Report of the Head of Development Management and Building Control Committee Report – Application Report

78464/APP/2024/3196

Site Address: **Dyson Drive, Uxbridge, UB10 0GJ**

Proposal: **The creation of 9no. off-street parking spaces and planting of 3no. new trees.**

Proposed Site Layout Scale 1:500

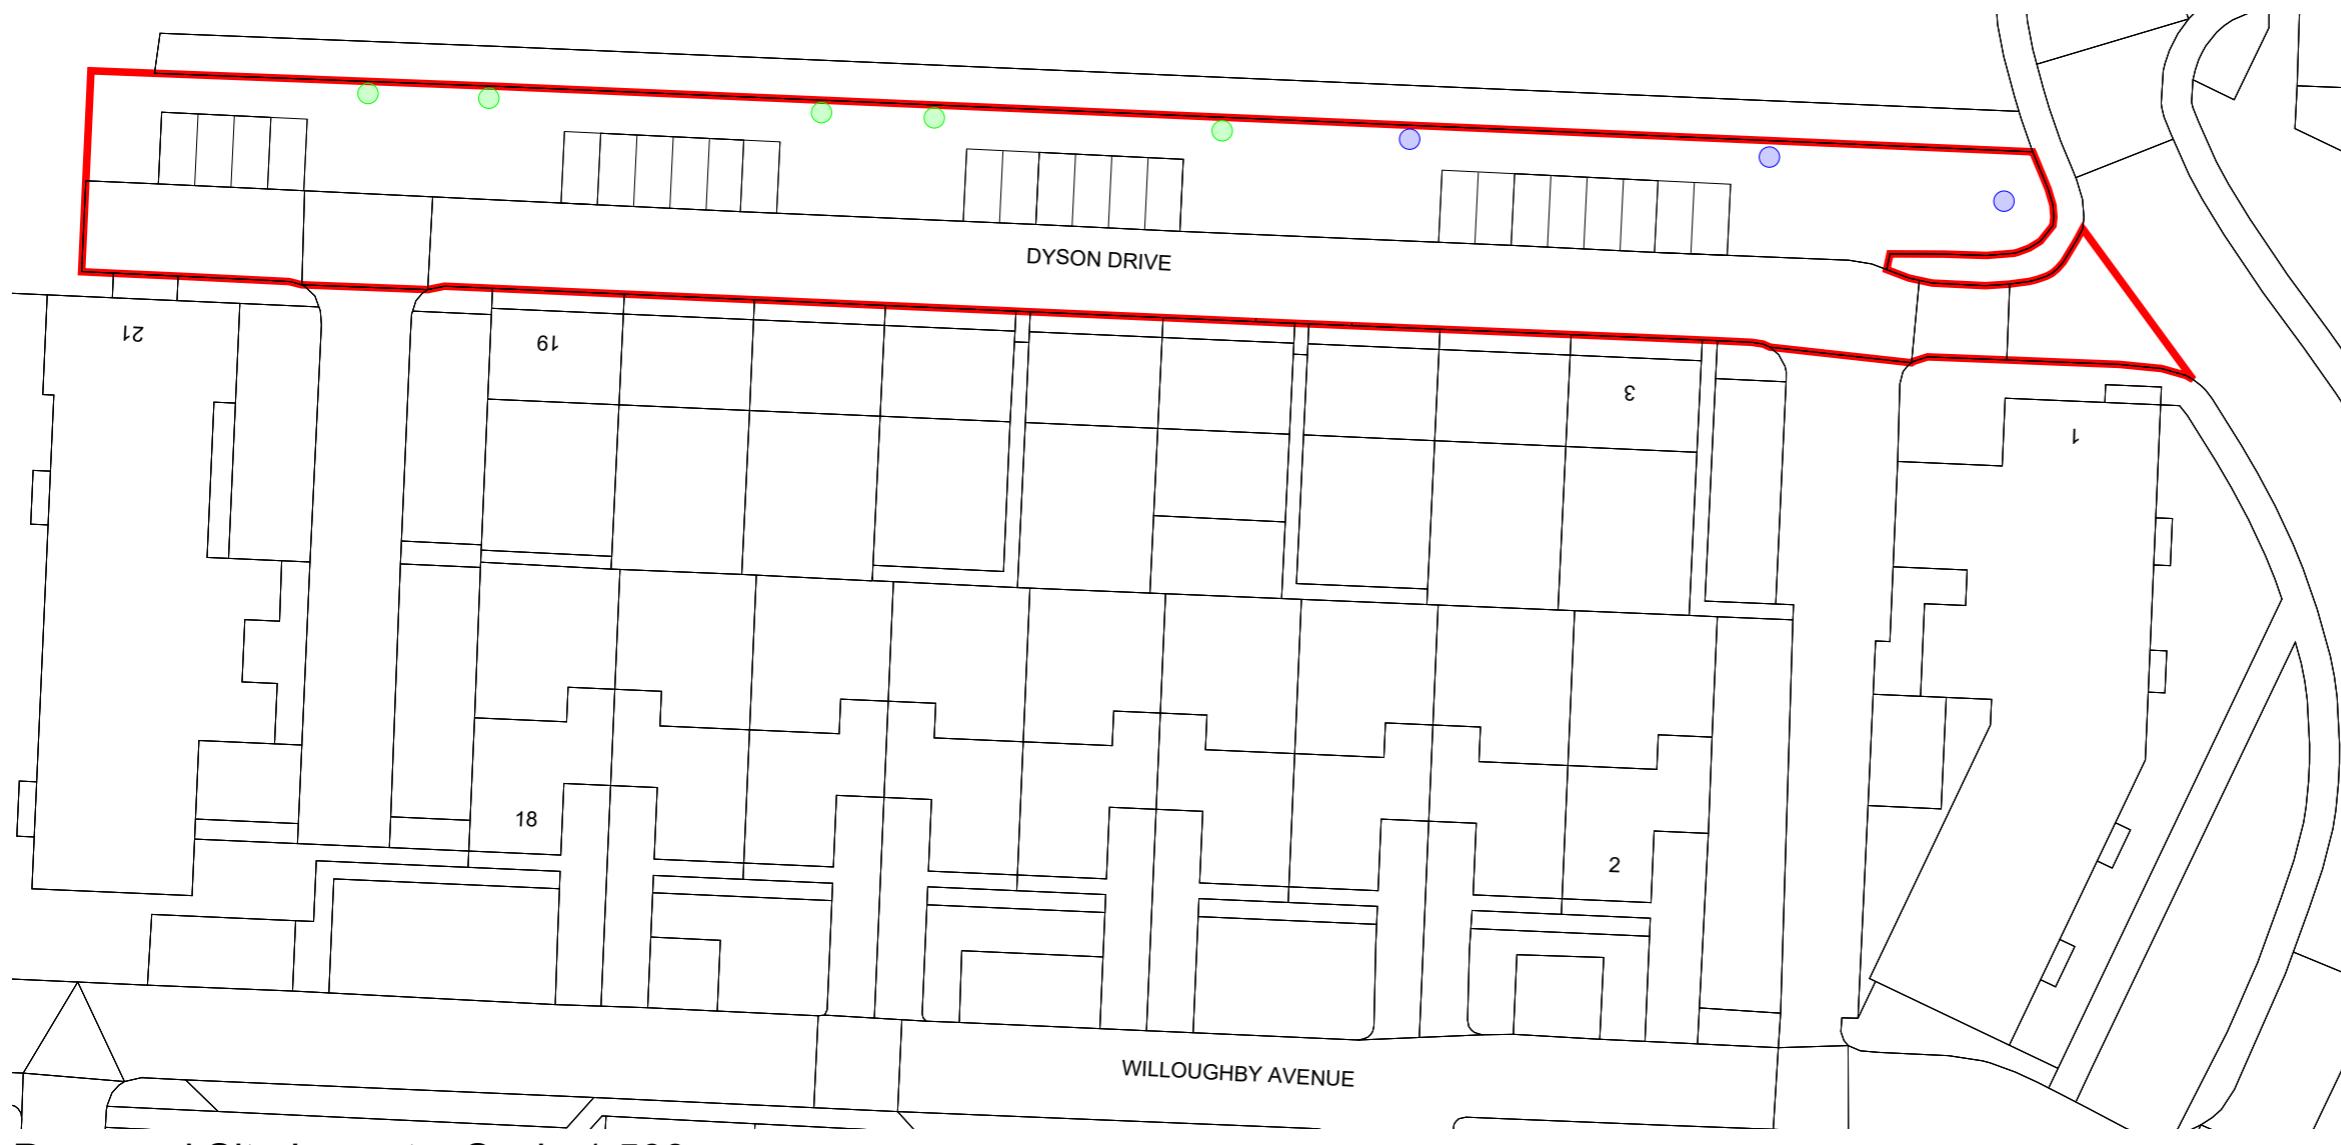
- 7.6 The proposed 9no. parking spaces would be allocated to homeowners on Dyson Drive. The Design and Access Statement suggests that the proposal would result in the removal of cars parking along the road and would improve the openness within the street scene. Drawing FLU.CP.02 titled 'Proposed Location and Site Plans' shows the proposed layout, which provides the additional car parking spaces adjacent to the existing rows of car parking spaces. Whilst the proposed arrangement would provide additional allocated parking spaces, due to the lack of parking controls on Dyson Drive, it is considered that the proposal would not resolve the existing informal parallel parking that currently occurs on the shared surface at Dyson Drive. It is therefore considered that the proposal could exacerbate the level of car parking and congestion on Dyson Drive.

- 7.7 As noted by the Highway Authority, the highway is a shared surface and the increase in formal parking spaces would increase the volume of traffic using Dyson Drive. The uplift in traffic volume would increase the potential for conflict with pedestrians and cyclists, which raises concerns on highway safety grounds. The proposal would fail to accord with the published NPPF Chapter 9 Promoting Sustainable Transport, the London Plan (2021) and London Borough of Hillingdon Local Plan Part 2 - Development Management Policies (2020).

- 7.11 The proposal would require the removal of green spaces alongside the existing parking bays to accommodate the new parking spaces. The new parking spaces are proposed to be surfaced with 'grasscrete'. Whilst an effort has been made to retain a green visual aspect, the proposed use of grasscrete is not considered to be a suitable or effective solution to offset the loss of green space.

- 7.12 The additional car parking spaces, the loss of green space, the proposed surfacing and the resulting proliferation of parked cars would be detrimental to the character of the area and would detract from the visual quality and usability of the landscaped pedestrian link, which is seen as an important part of the estate. The level of harm identified, is however on balance, not considered to be significant to warrant a separate reason for refusal.

- 7.14 There are no direct issues that are purely related to accessibility matters. However, it is worth noting that the proposed layout shows the car parking to be accessed via the shared surface, increasing the number of vehicle movements and therefore the potential risks for pedestrians and cyclists. This raises concerns on highway safety grounds, but is not considered to be a separate reason for refusal.
